From: Contact Centre (CRM) <contact@ribblevalley.gov.uk>
Sent: 05 August 2026 13:27
To: Planning
Subject: Planning Application Comments - 3/2026/0452 FS-Case-863011275

Planning Application Reference No.: 3/2026/0452

Address of Development: 3a Swan Courtyard, Clitheroe

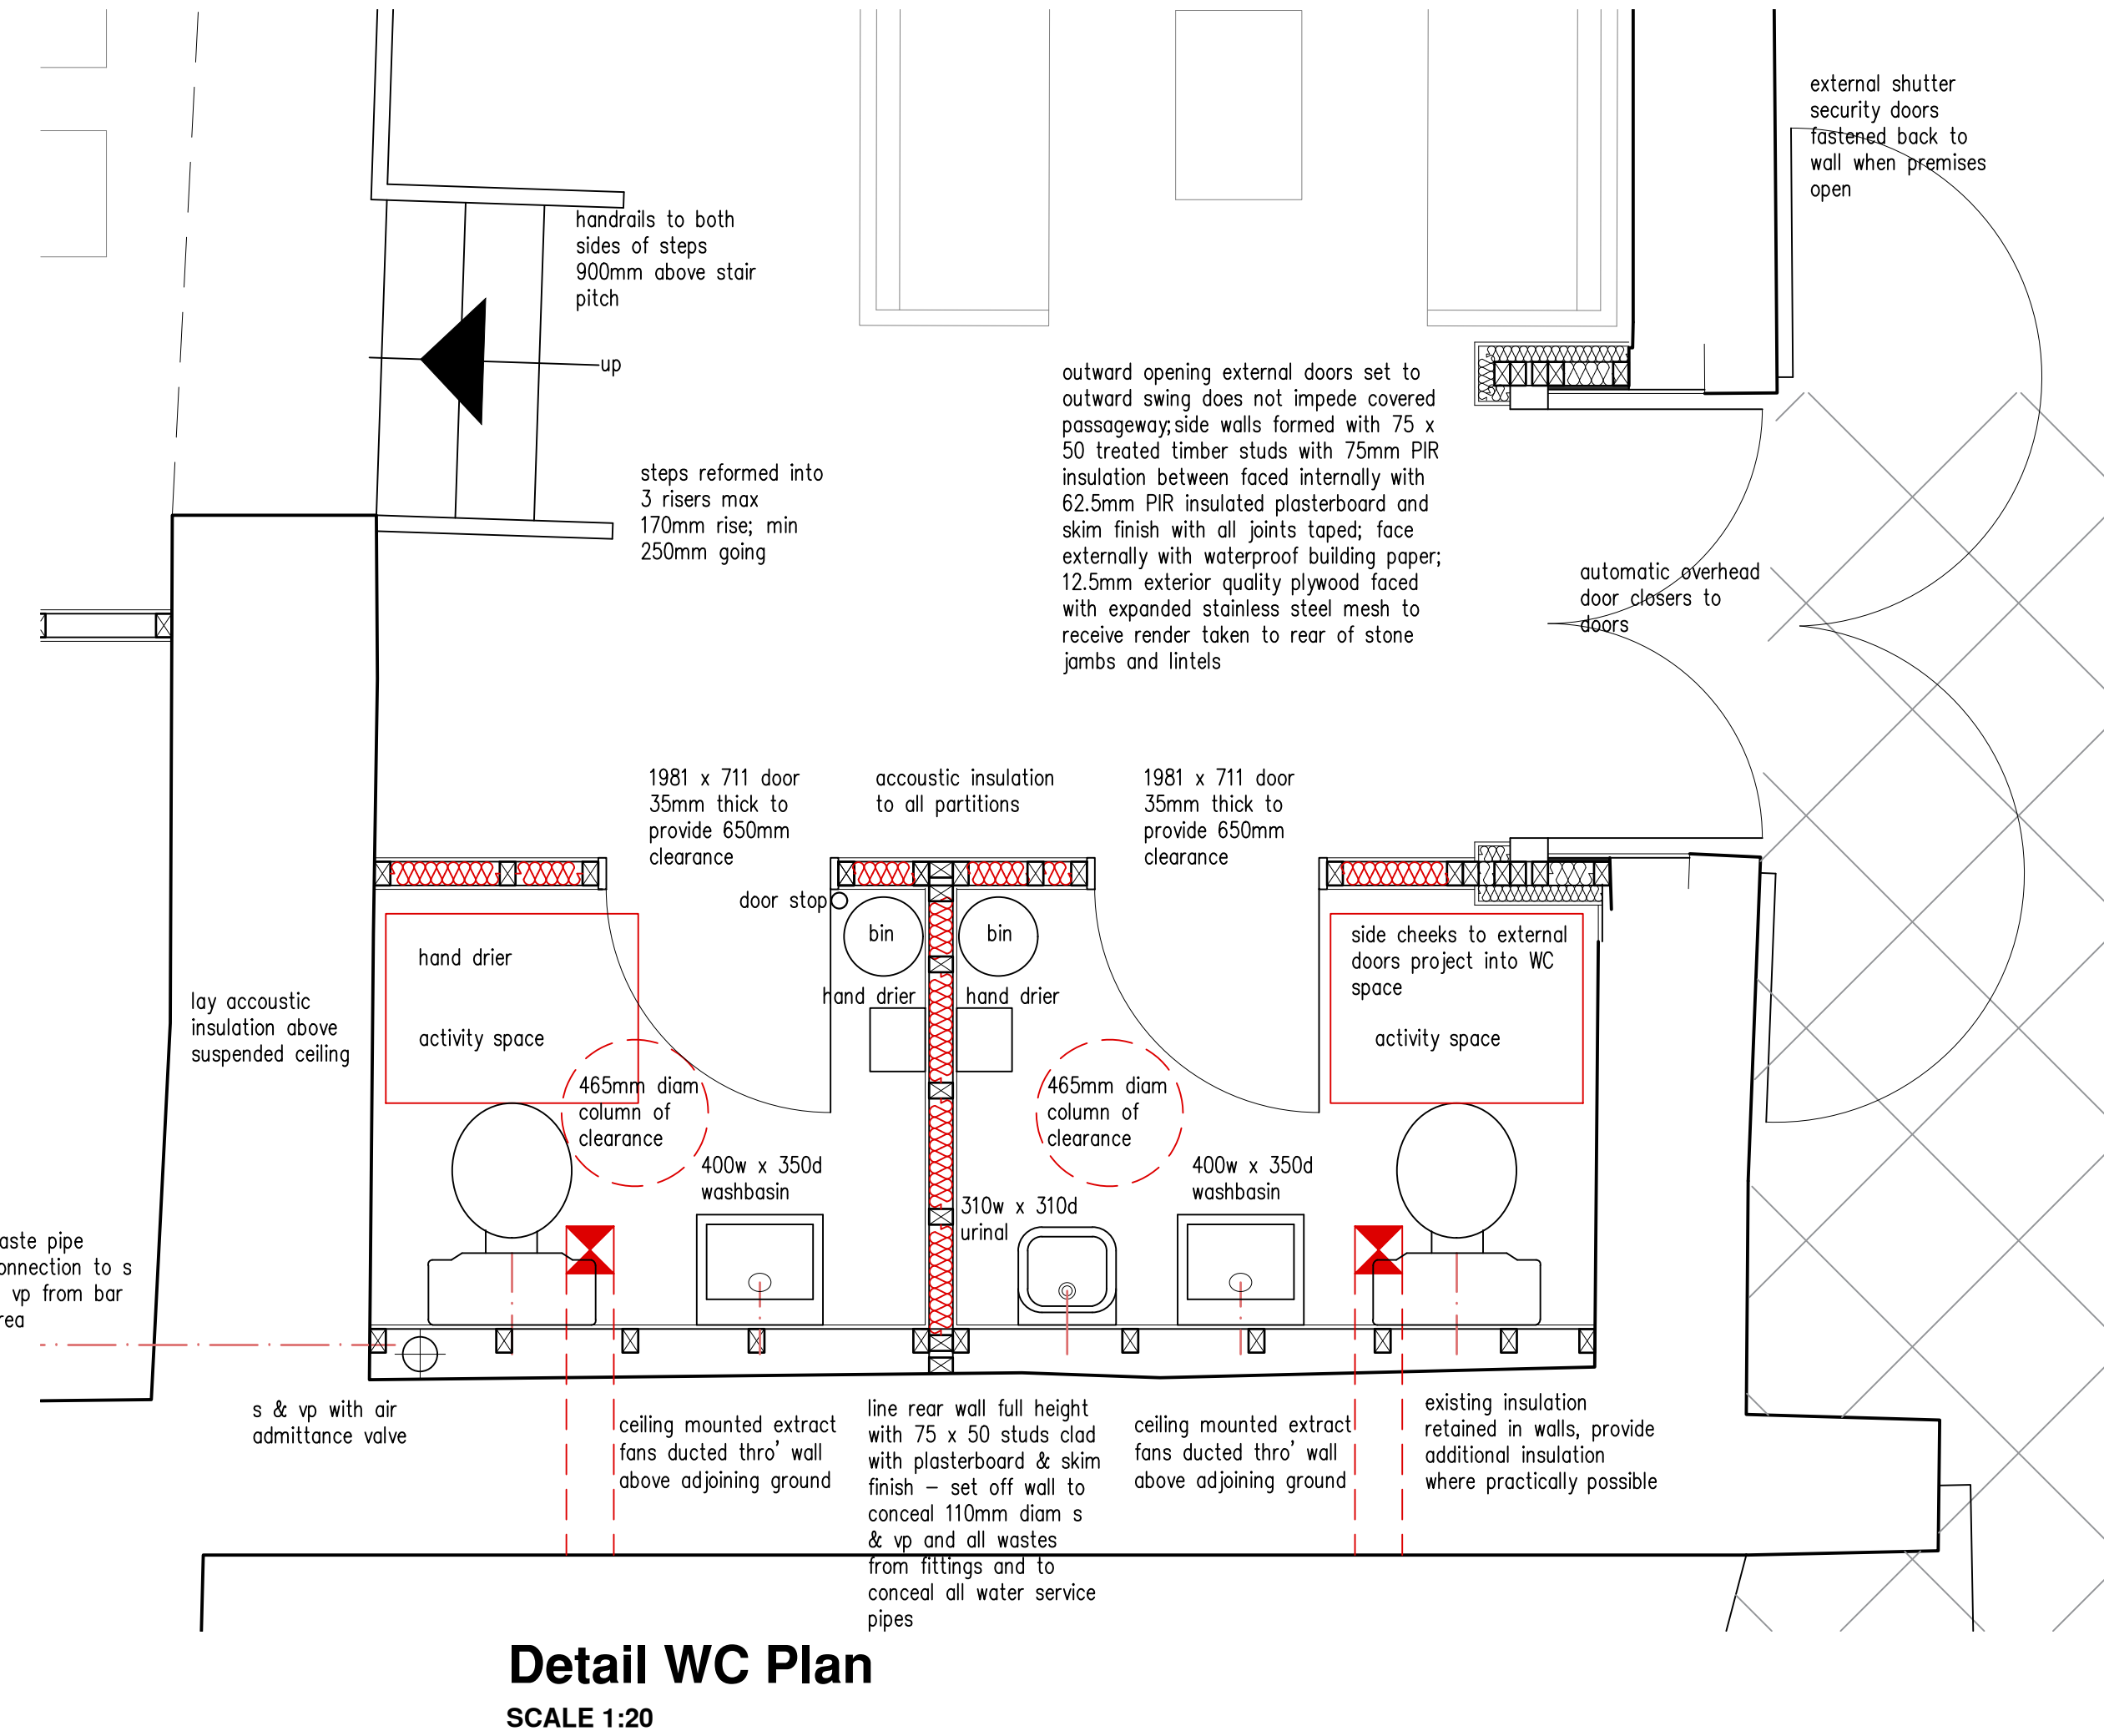
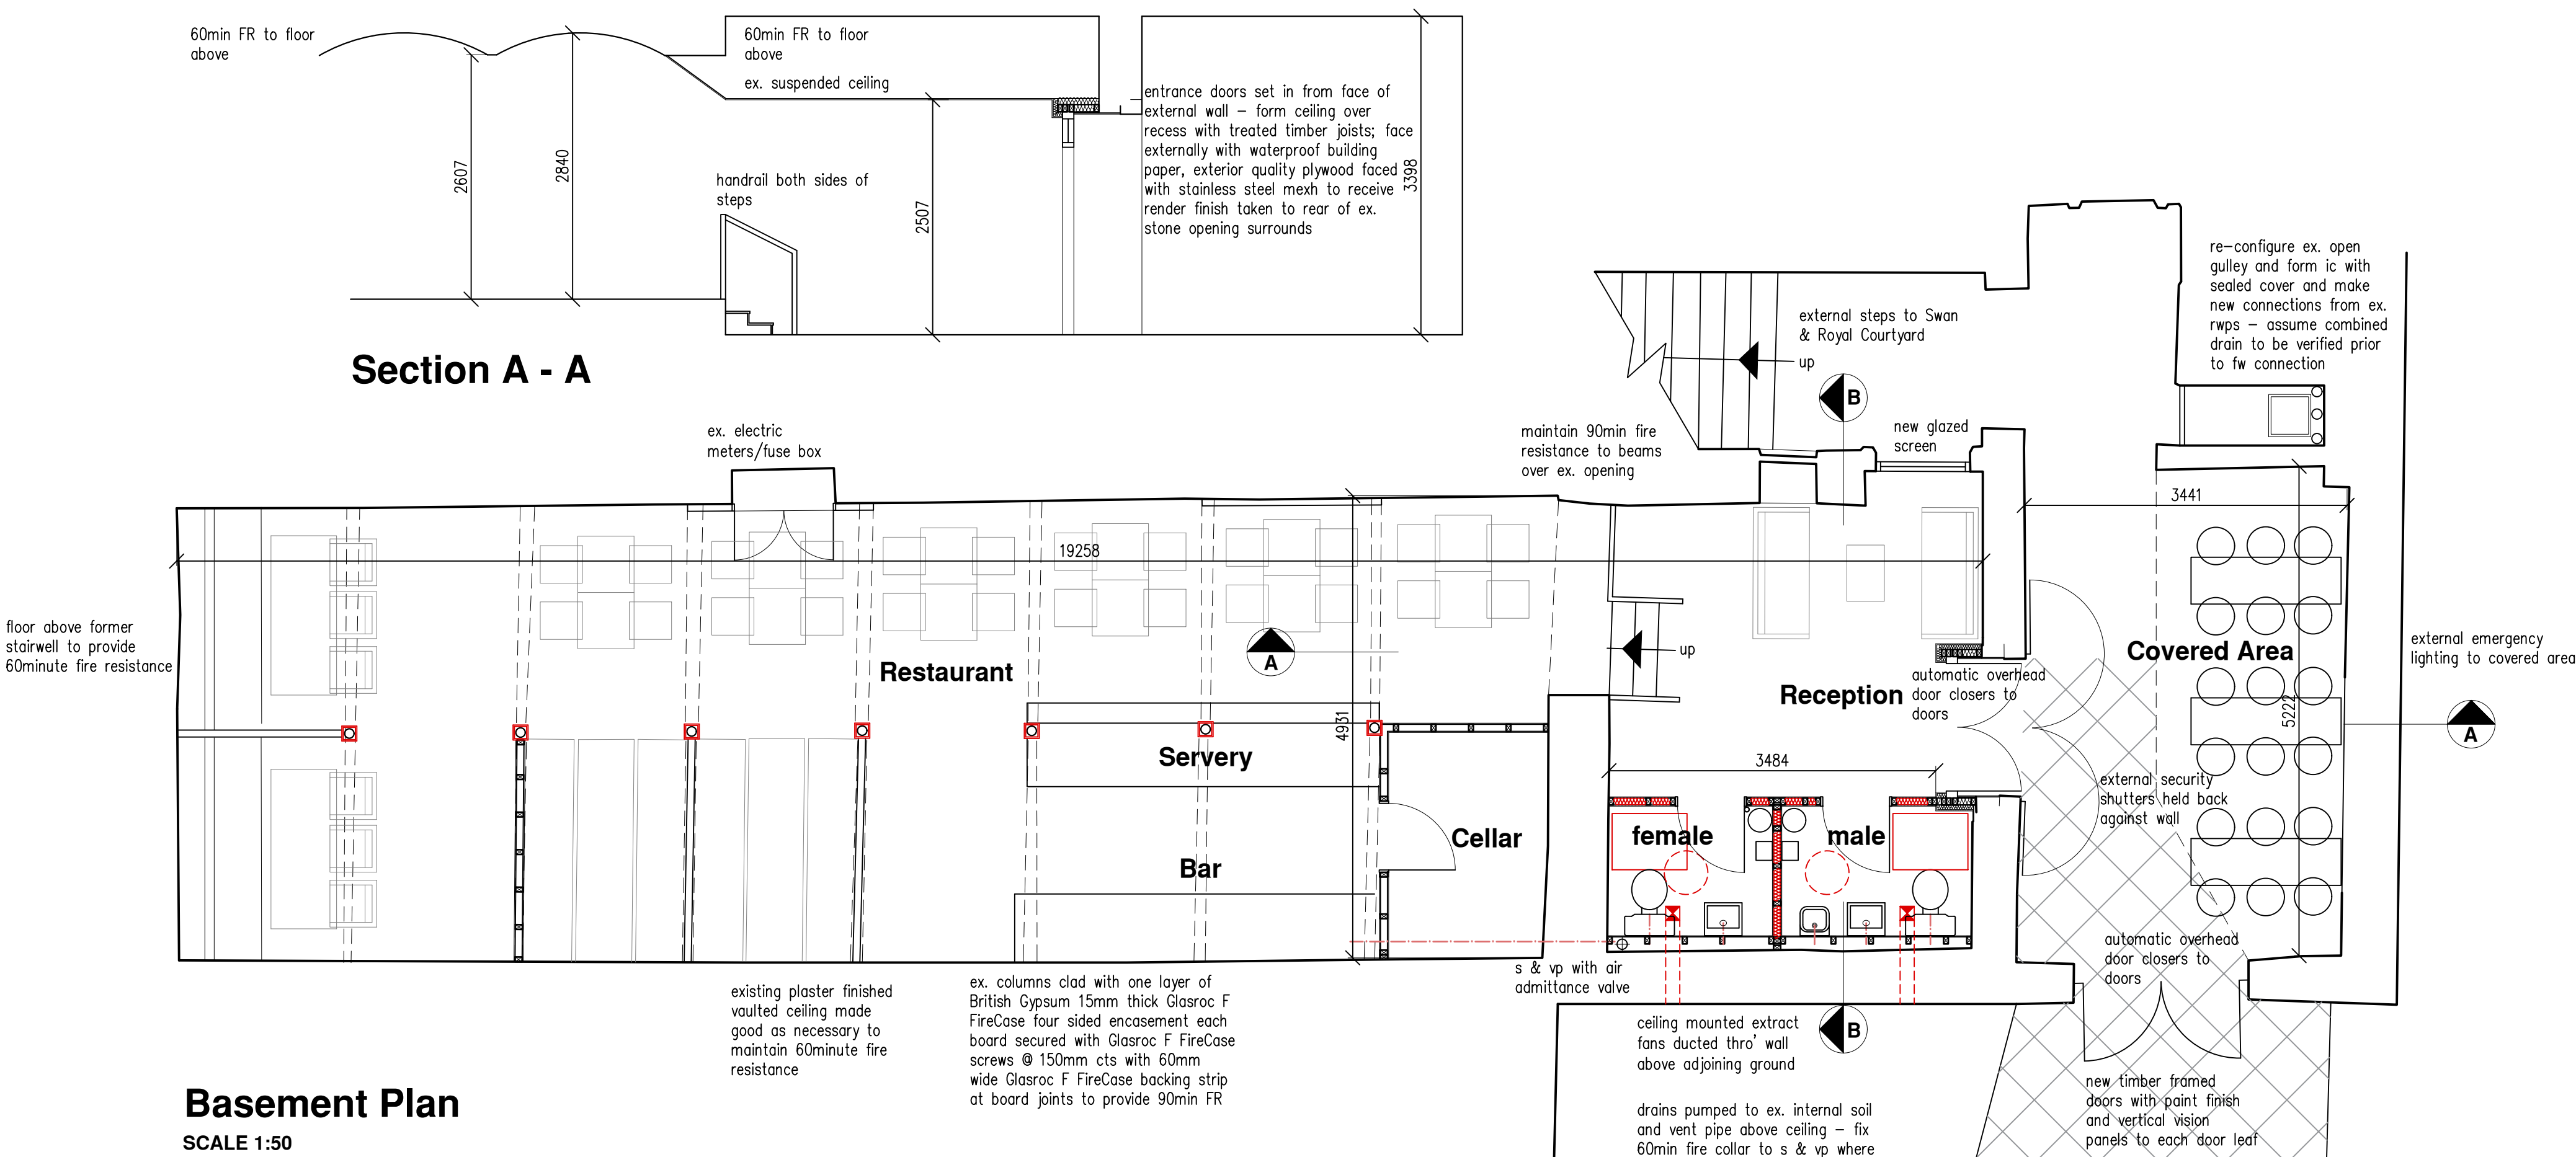
1) The South West elevation does not appear to show the impact of external venting from the new male and female loos in Churchills, yet they are referenced in the overhead plans - not sure if this is an oversight or if the venting will utilise existing external features in the SW elevation? Although potentially minor, there may be visual impact and as part of the Conservation Area, any impact needs to be actively assessed.

2) the SW elevation plan shows new doors placed in the existing archway leading up from Lowergate car park. Whilst the visual impact is relatively low, due to the materials used, the [REDACTED] does have concerns about the lack of unhindered public access through from the car park or vice versa from the Swan courtyard. One assumes that the entry doors are capable of being closed/secured - has the applicant fully detailed whether the doors will always be open regardless of the time of day/night? As the steps from the courtyard would be open in any case, it would be potentially dangerous to create an area that was secured at one end but not at the other. If the applicant intends for these doors to always remain openable at any time, then the [REDACTED] does not hold concern. However if the doors can be locked or secured, that would or could impede public access through and as the route has certainly been publicly accessible for well over 20 years (probably over double that) and no barrier or locked approaches have ever been in place on this route, the route would constitute a Prescriptive Right and one that needs to be maintained irrespective of ownership.
